24 X 30 GARAGE

**APPROVED**  
Limited building only review  
Permit holder responsible for full compliance with the code

02/11/2022

STEMWALL FOOTING

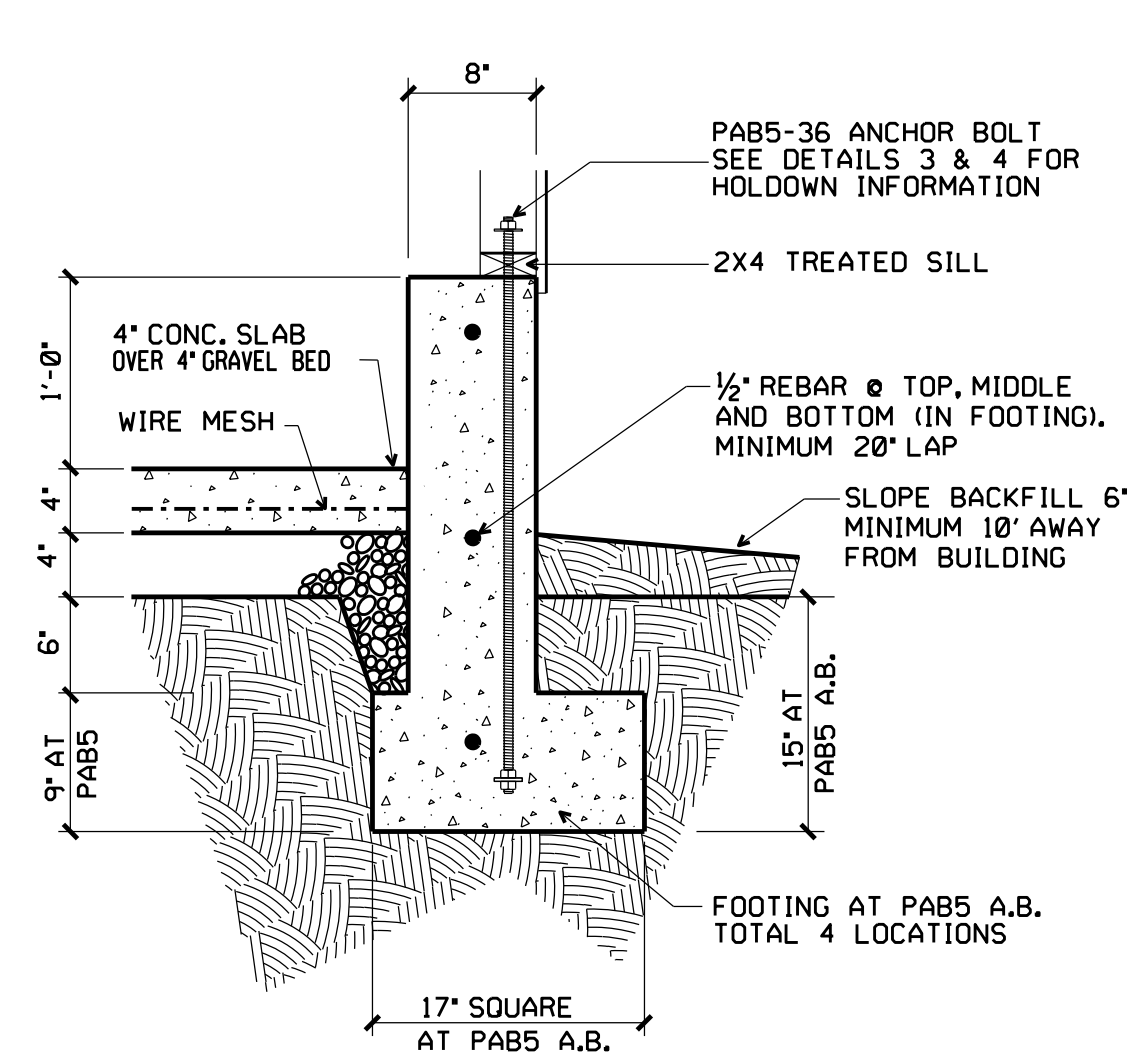
See footing note. Complete truss package must be onsite for rough inspections
